Viking CCS Pipeline

9.41 Design Changes 5 to 8: Environmental Technical Note

Document Reference: EN070008/EXAM/9.41

Applicant: Chrysaor Production (U.K.) Limited,
a Harbour Energy Company
PINS Reference: EN070008
Planning Act 2008 (as amended)
The Infrastructure Planning (Applications: Prescribed Forms
and Procedure) Regulations 2009 - Regulation 5(2)(q)
Date: June 2024

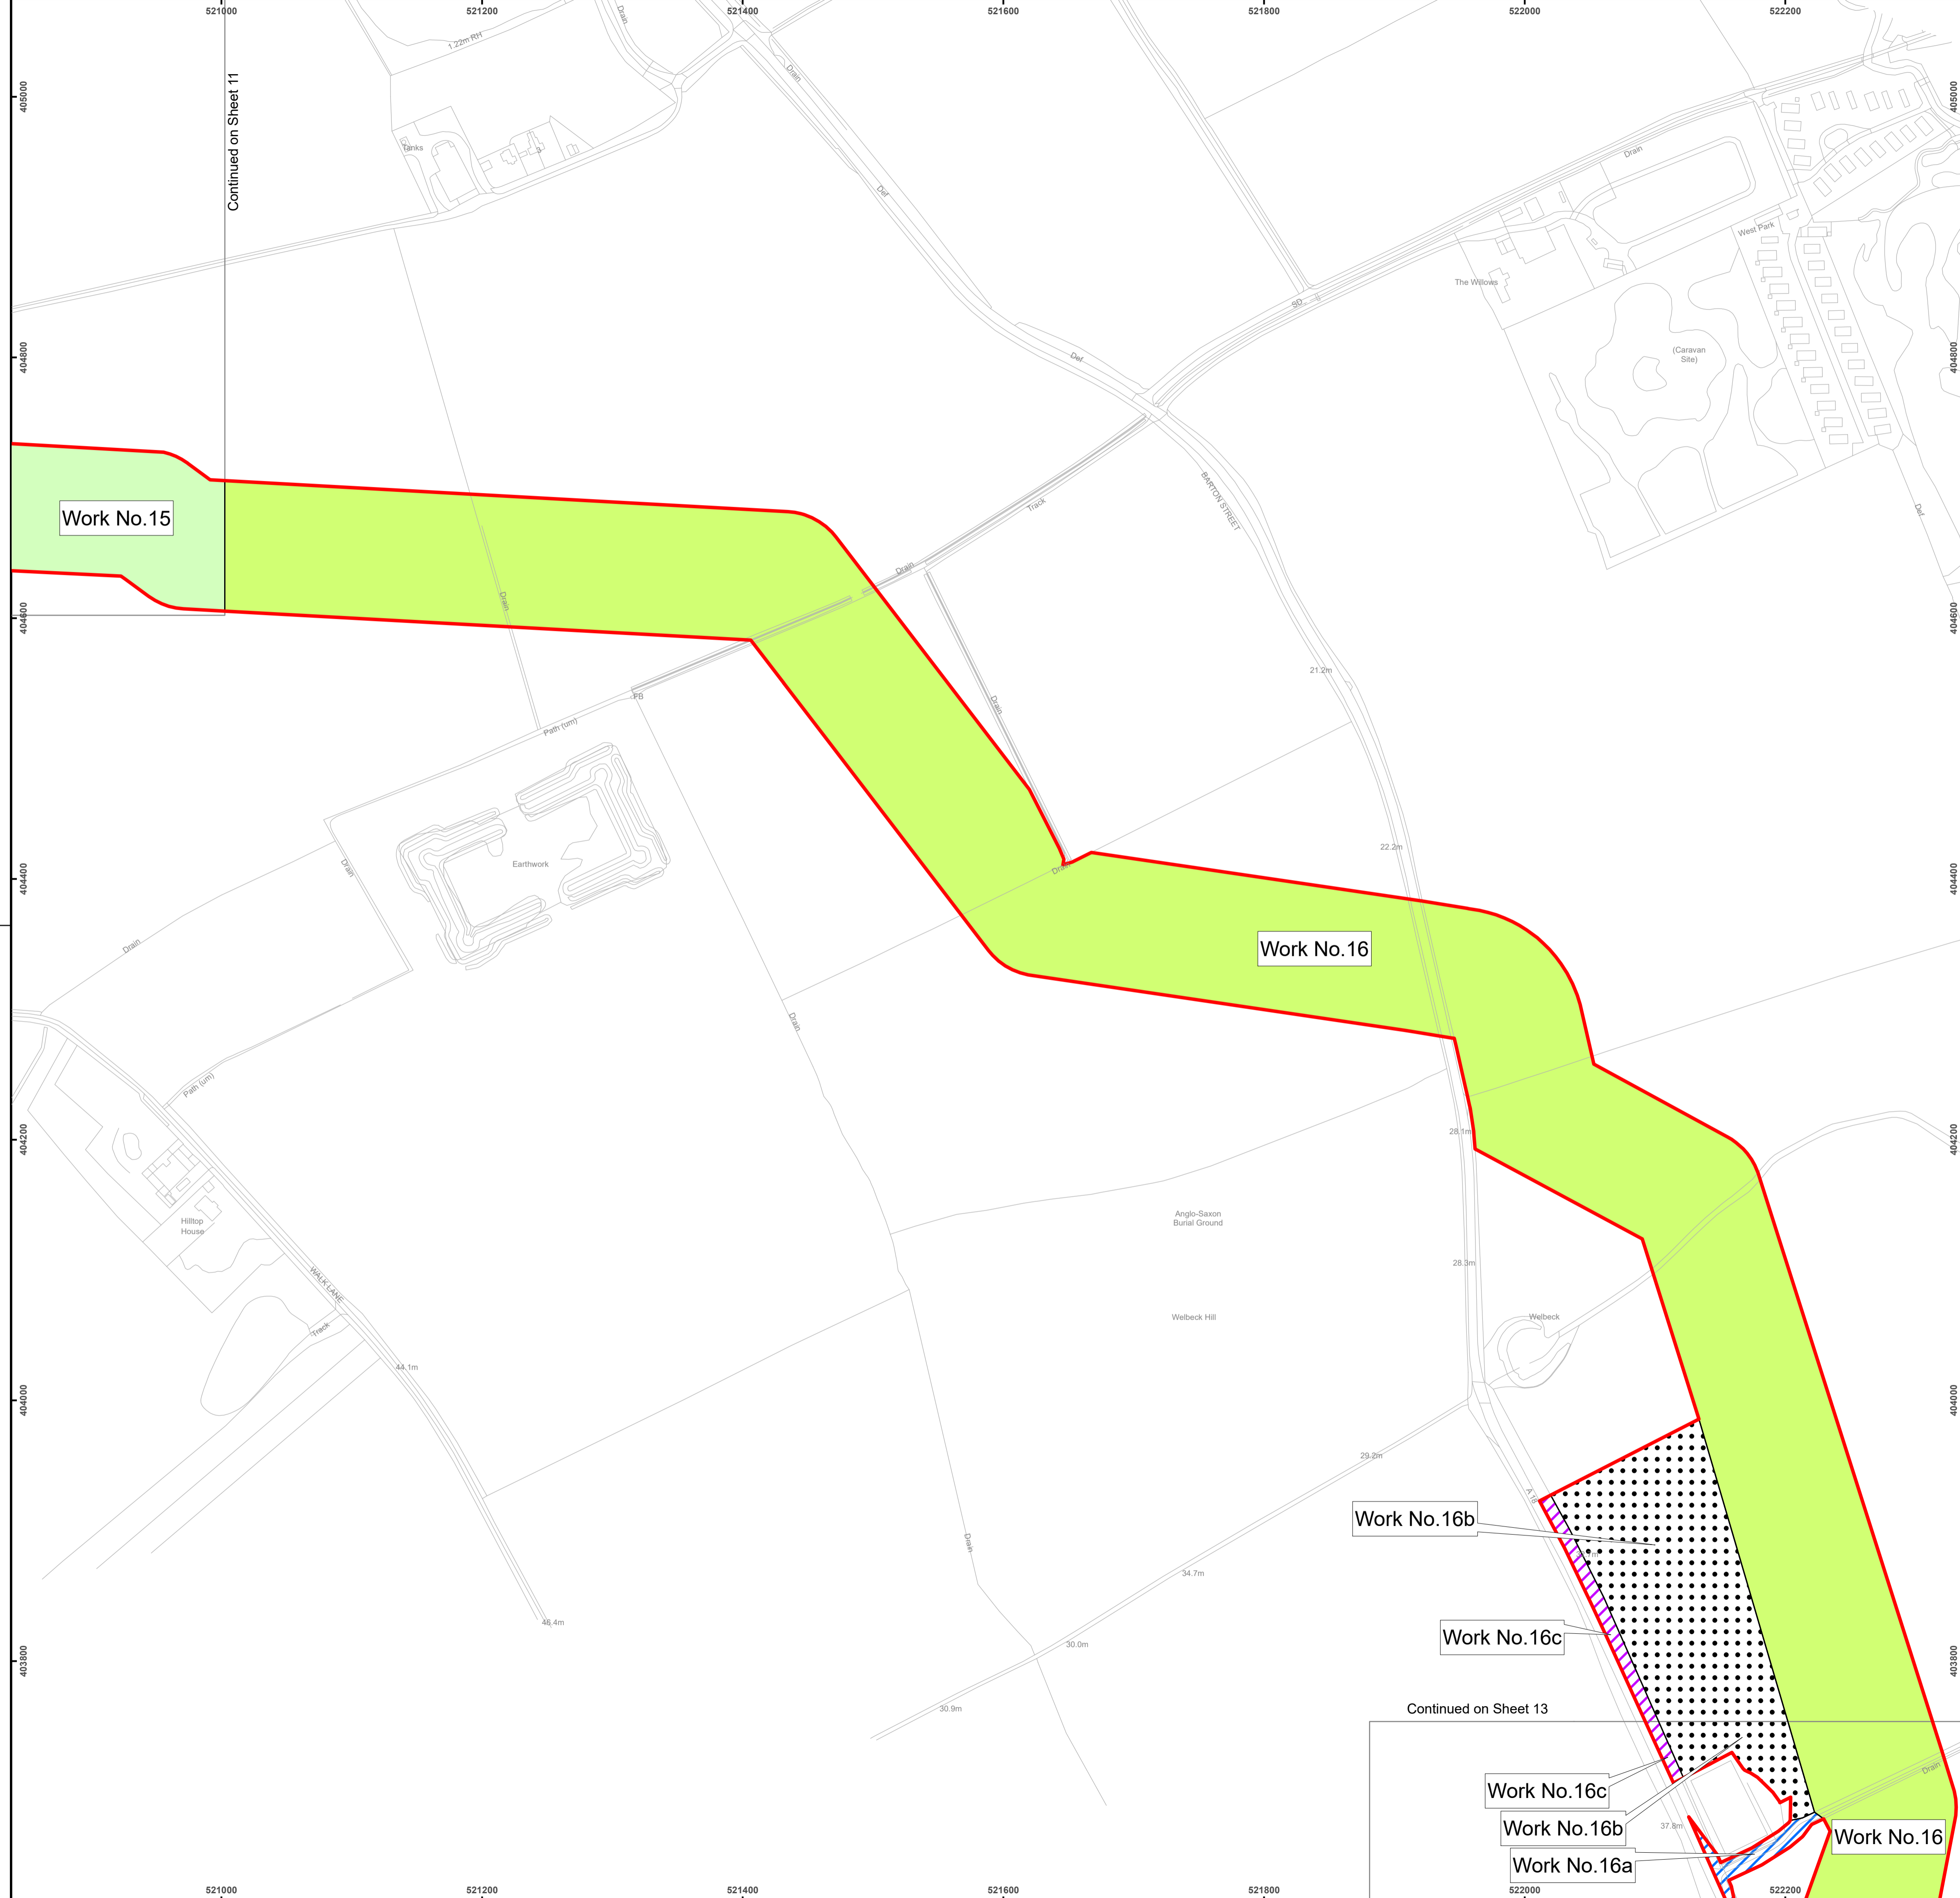
- Change 8: Removal of construction access point 11-AD in North East Lincolnshire that adjoins the A46 west of Laceby (removal of land from the Order Limits in Works No. 15a).

- 2.5.1 During discussions with the Local Highway Authority, North East Lincolnshire Council has also raised concern that adequate visibility may not be available for drivers entering and exiting construction access 11-AD leading north from A46. It is proposed that this access is removed from the Proposed Development and the Order Limits reduced accordingly.

- 2.5.2 This change would result in alterations to the Order Limits associated with the above Works Nos. The change would reduce the area of land included in the Order Limits and would not engage any new land interests. No additional land outside of the current Order Limits is required. This change would not result in new or different likely significant environmental effects reported in the ES.

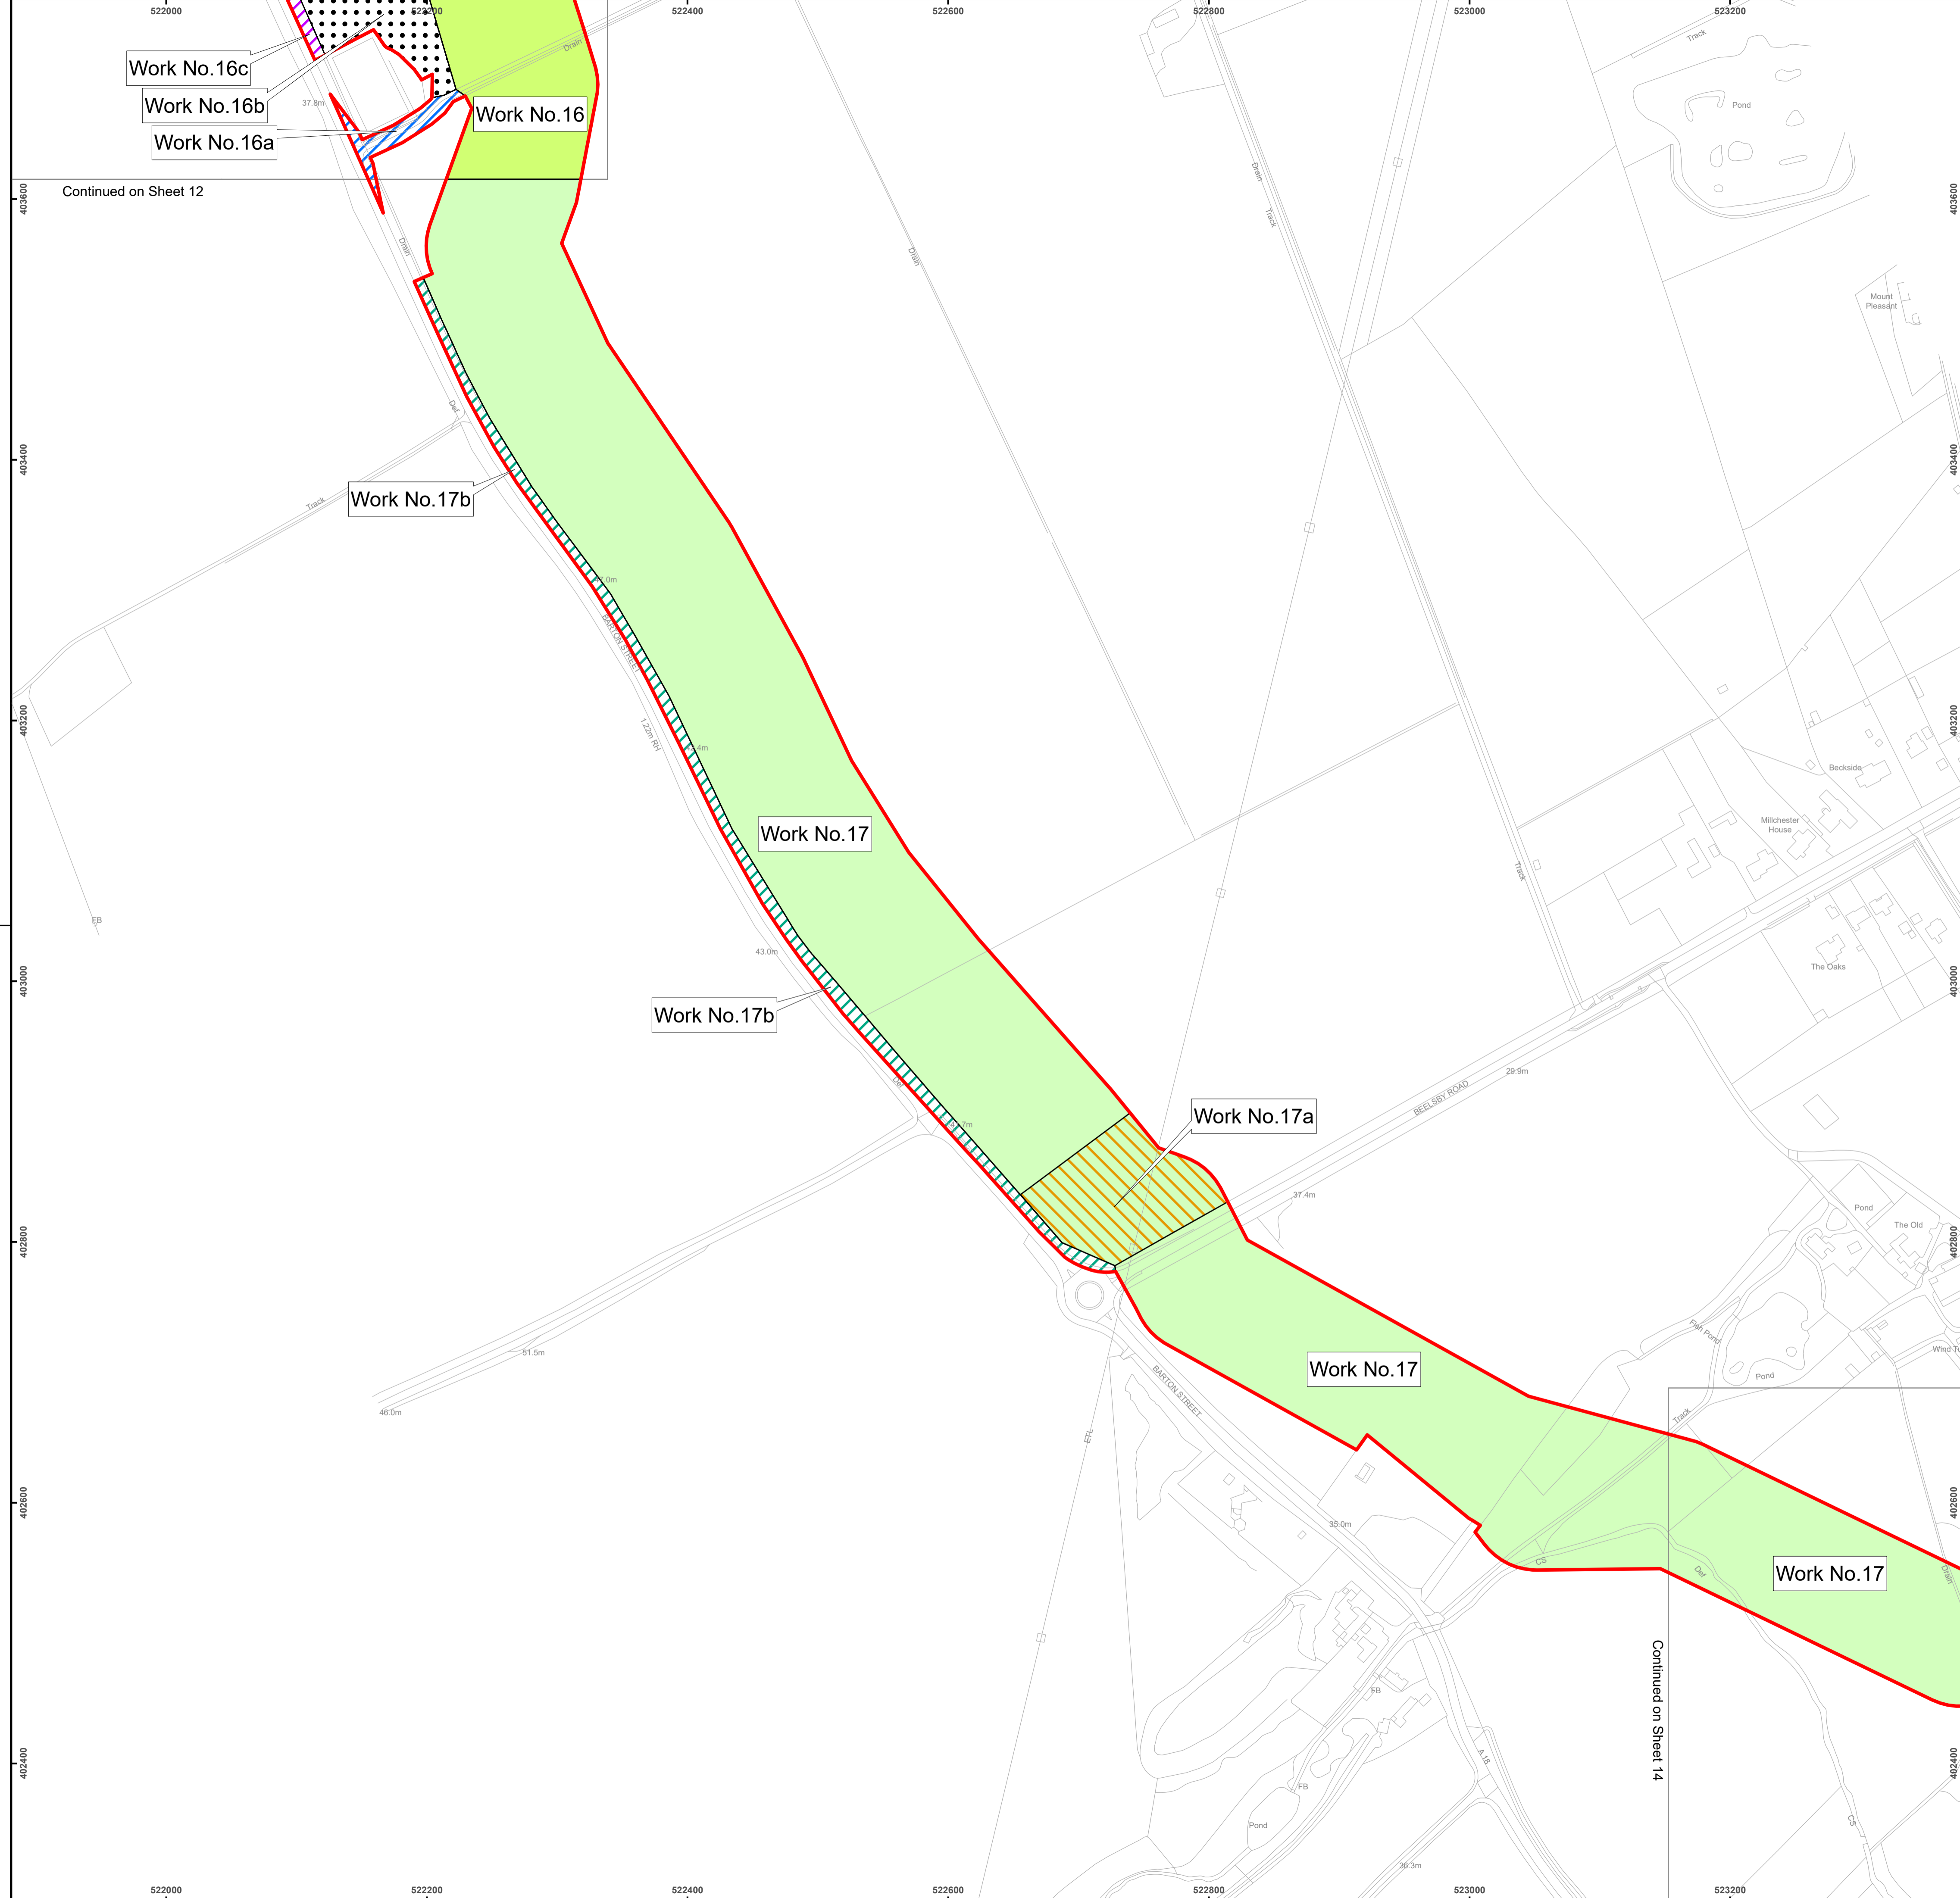
- Change 7: Removal of construction access point 12-AB in North East Lincolnshire that adjoins the A18 Barton Road south of Laceby (removal of land from the Order Limits in Works No. 16a); and

- 2.4.1 The Proposed Development includes a number of vehicle access points along the route of the pipeline that will be used during the construction stage for the delivery of construction materials and plant. The Applicant has engaged with the Local Highway Authorities during the examination period. During these discussions, North East Lincolnshire Council has raised concern that adequate visibility may not be available for drivers entering and exiting construction access 12-AB leading east from the A18 in North East Lincolnshire. It is proposed that this access is to be removed from the Proposed Development and the Order Limits reduced accordingly.

- 2.4.2 This change would result in a reduction of the Order Limits associated with Works No.16a. The change would reduce the area of land included in the Order Limits and would not engage any new land interests. No additional land outside of the current Order Limits is required. This change would not result in new or different likely significant environmental effects reported in the ES.
